24 February 2026

Our reference: 230455, 201223

RE: SSD-31179510 Amendment Report at 2A Gregory Place, Harris Park (Gregory Place Build-to-Rent)

Publicly Accessible Green Spine

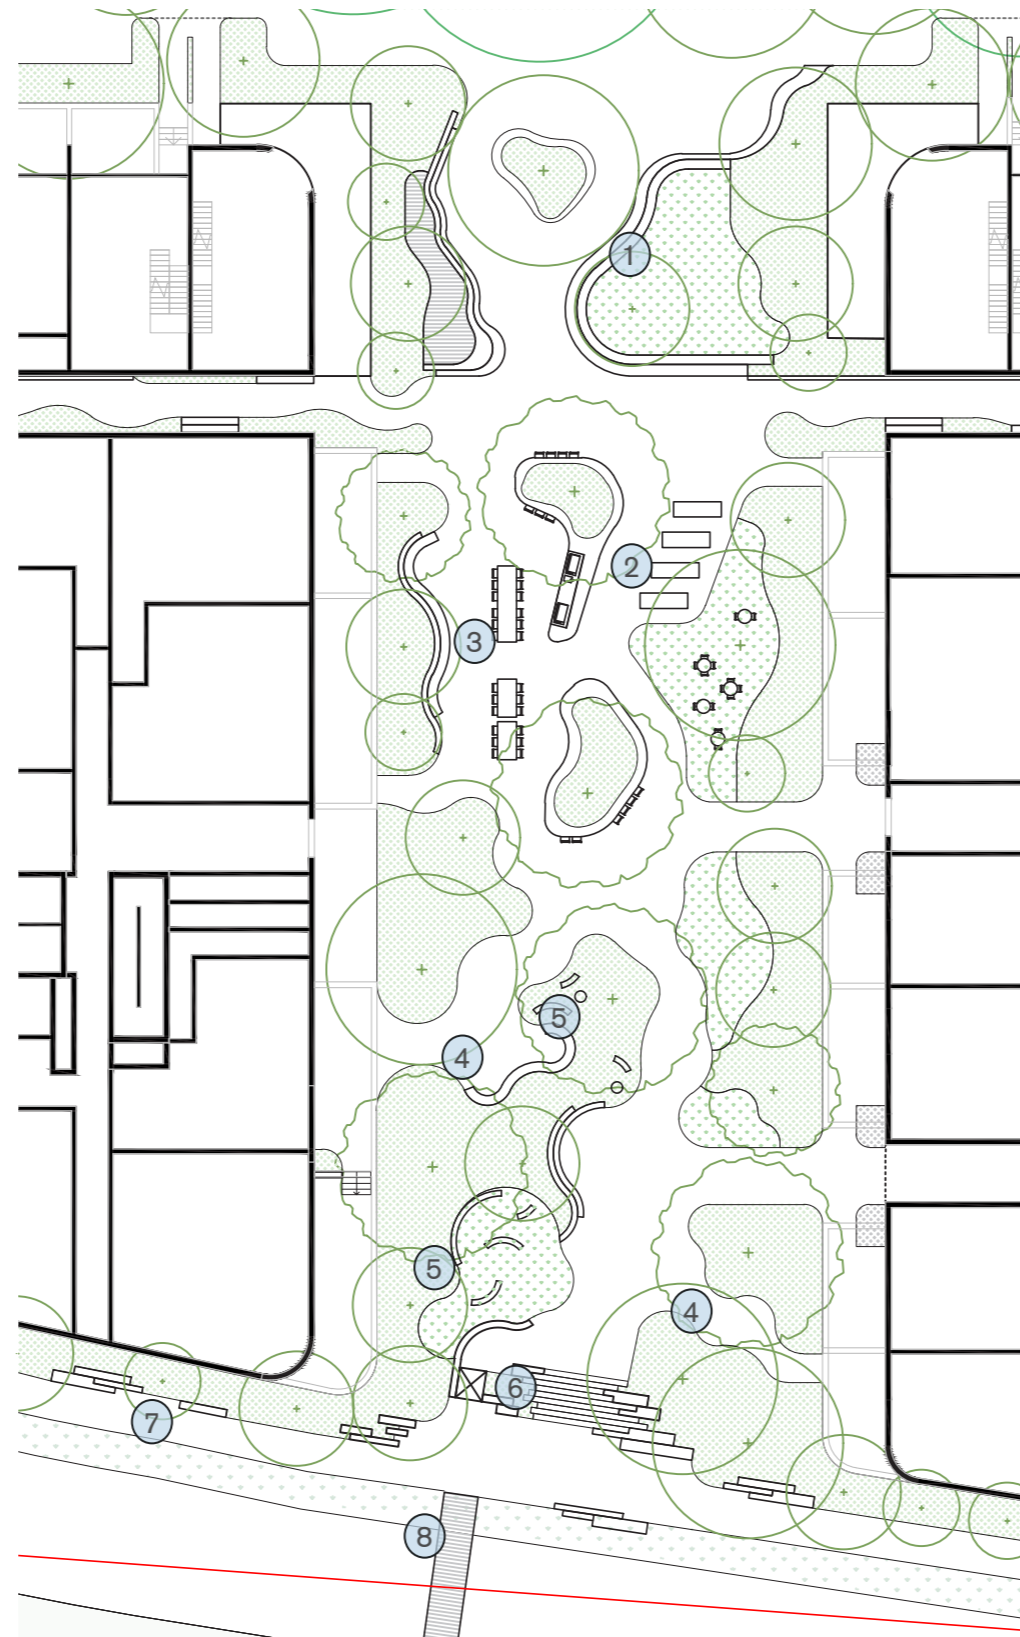
As per Sydney Water's [Building bridges over our open stormwater channels guidelines SW107](#), the proponent must provide evidence that the proposed bridges are required solely to access landlocked properties. Sydney Water will not grant permission for bridges that serve as a second access point to a property.

6.2.7 Clay Cliff Creek Stormwater Channel Walk

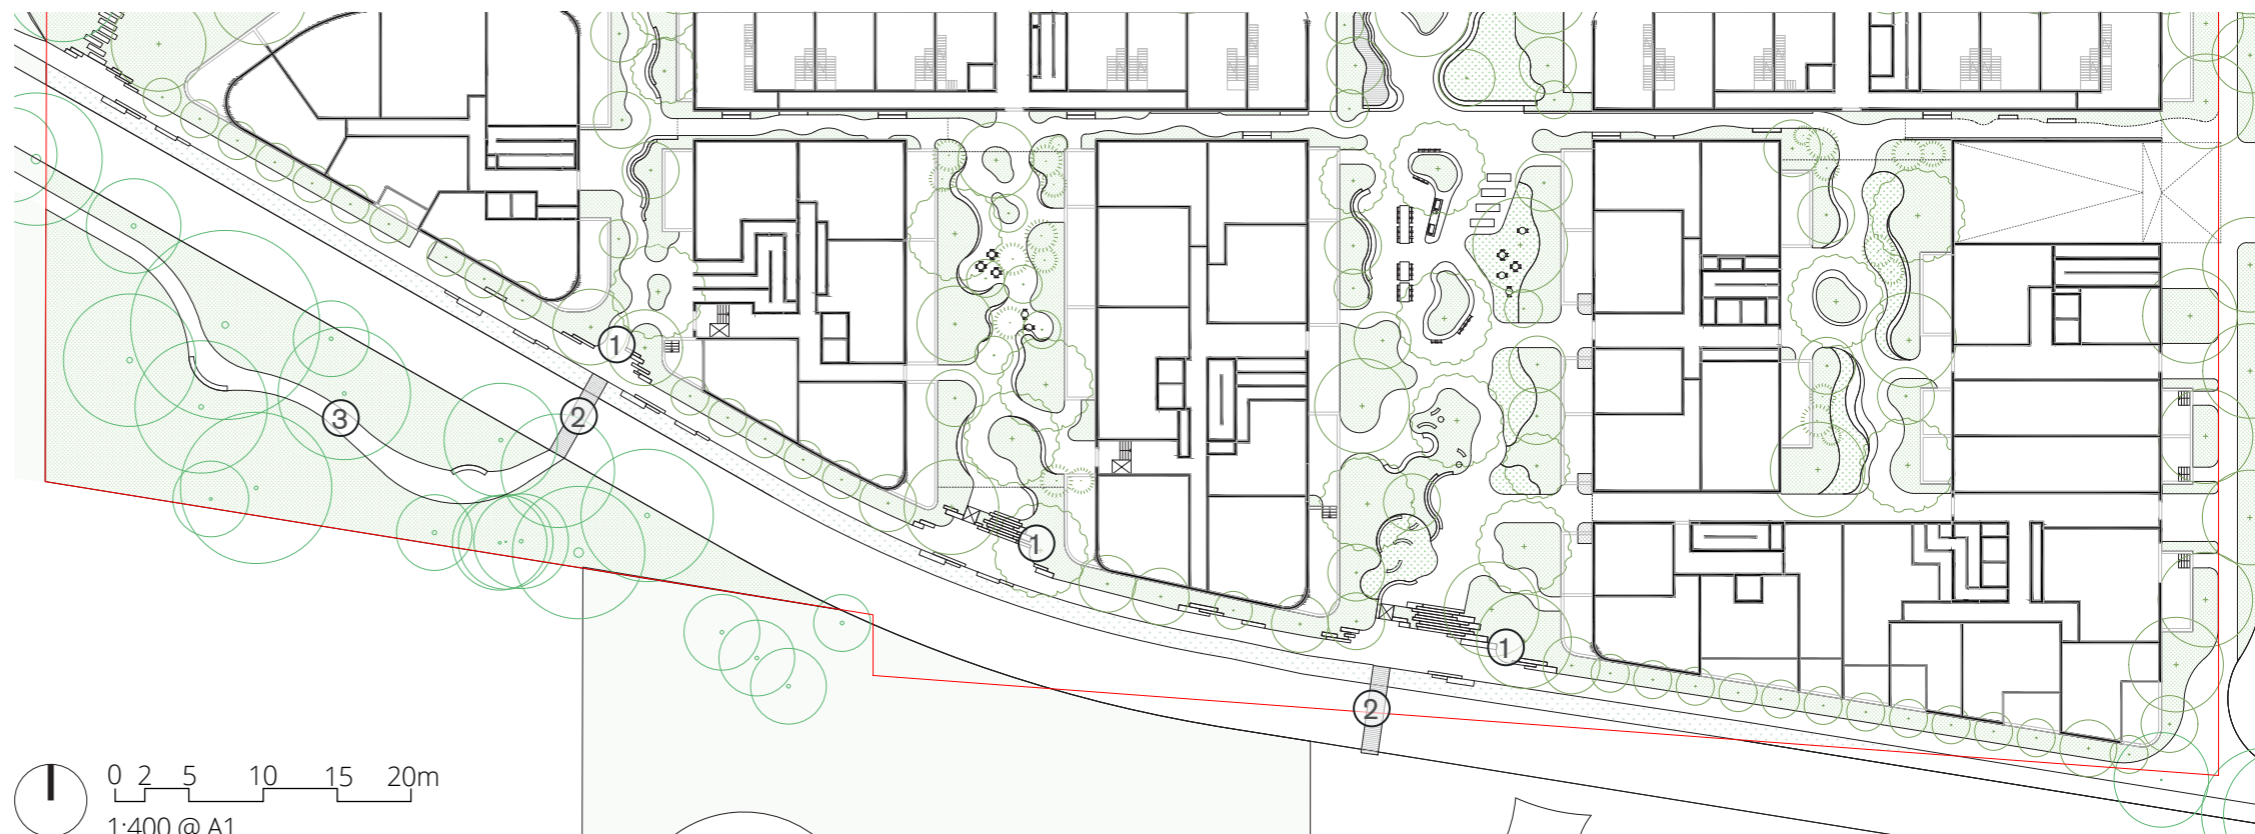
The proponent must ensure that the proposed Clay Cliff Creek walk is located at least 1.5m away from outside face of the Clay Cliff Creek wall.

Figure.124 South Elevation - Channel Walk

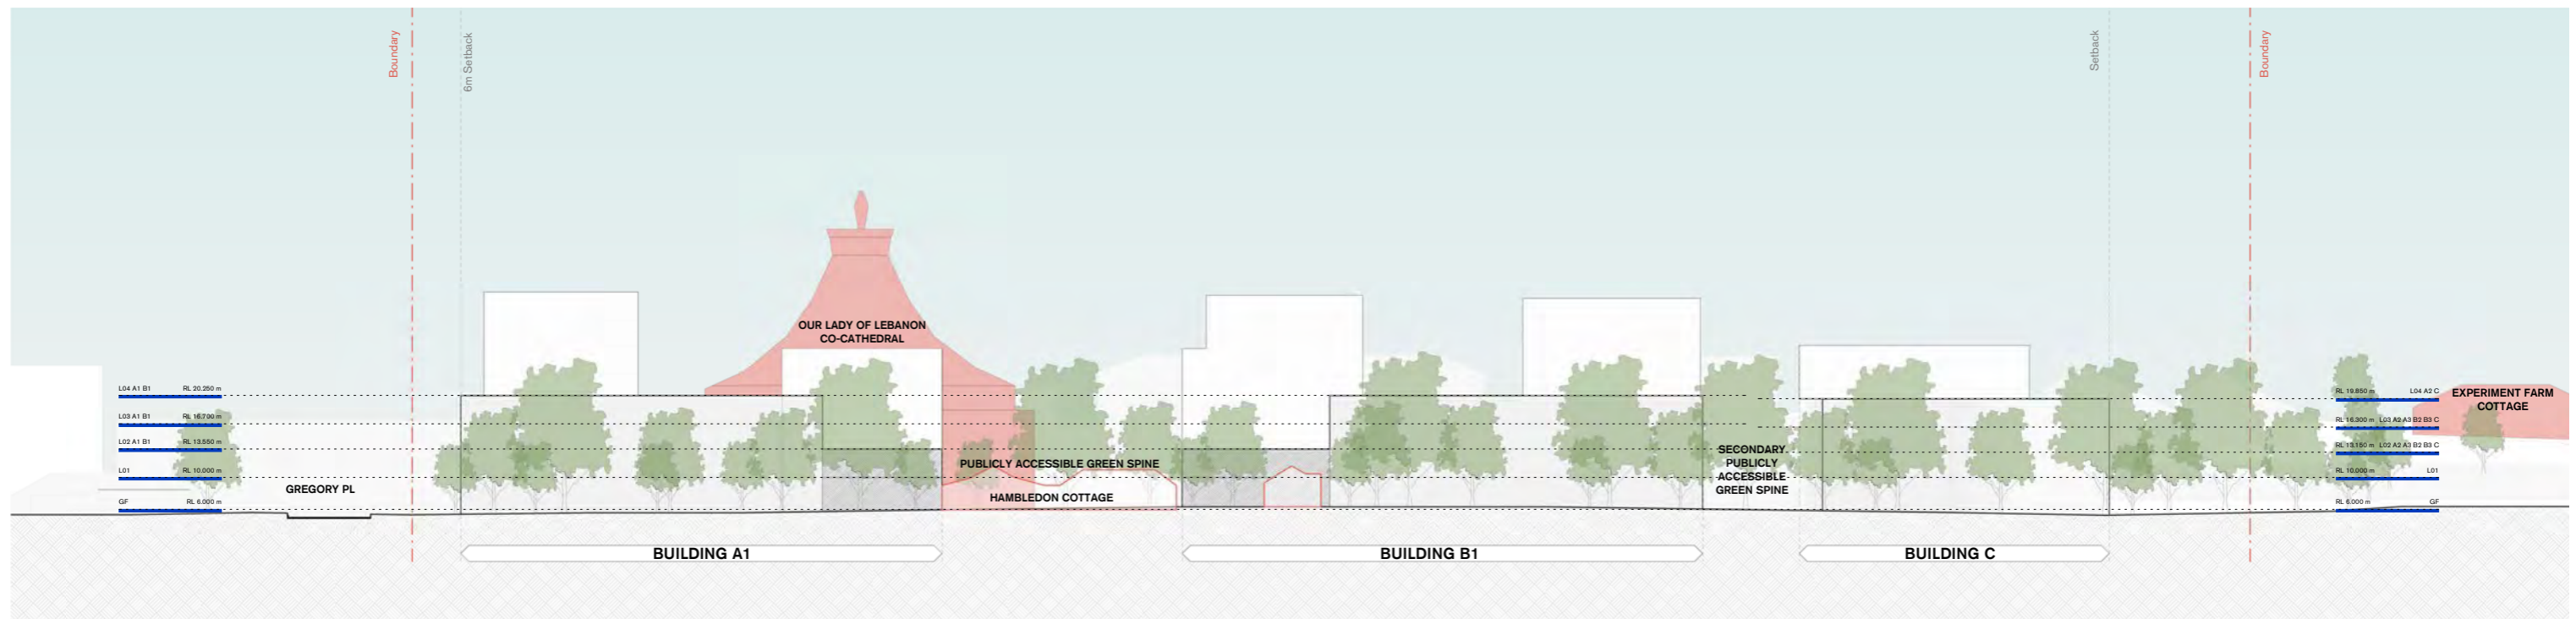
No buildings or permanent structures are to be proposed over the stormwater channel or within **1.5m** from the outside wall of the channel or within Sydney Water easement whichever is larger. Permanent structures include (but are not limited to) basement car park, hanging balcony, roof eaves, hanging stairs, stormwater pits, stormwater pipes, elevated driveway, basement access or similar structures. This clearance requirement would apply for unlimited depth and height.

The proponent is required to submit the elevation drawings with the stormwater channel/pipe, to ensure that the proposed buildings and permanent structures are 1.5m away from the outside face of the stormwater channel and away from the Sydney Water easement.
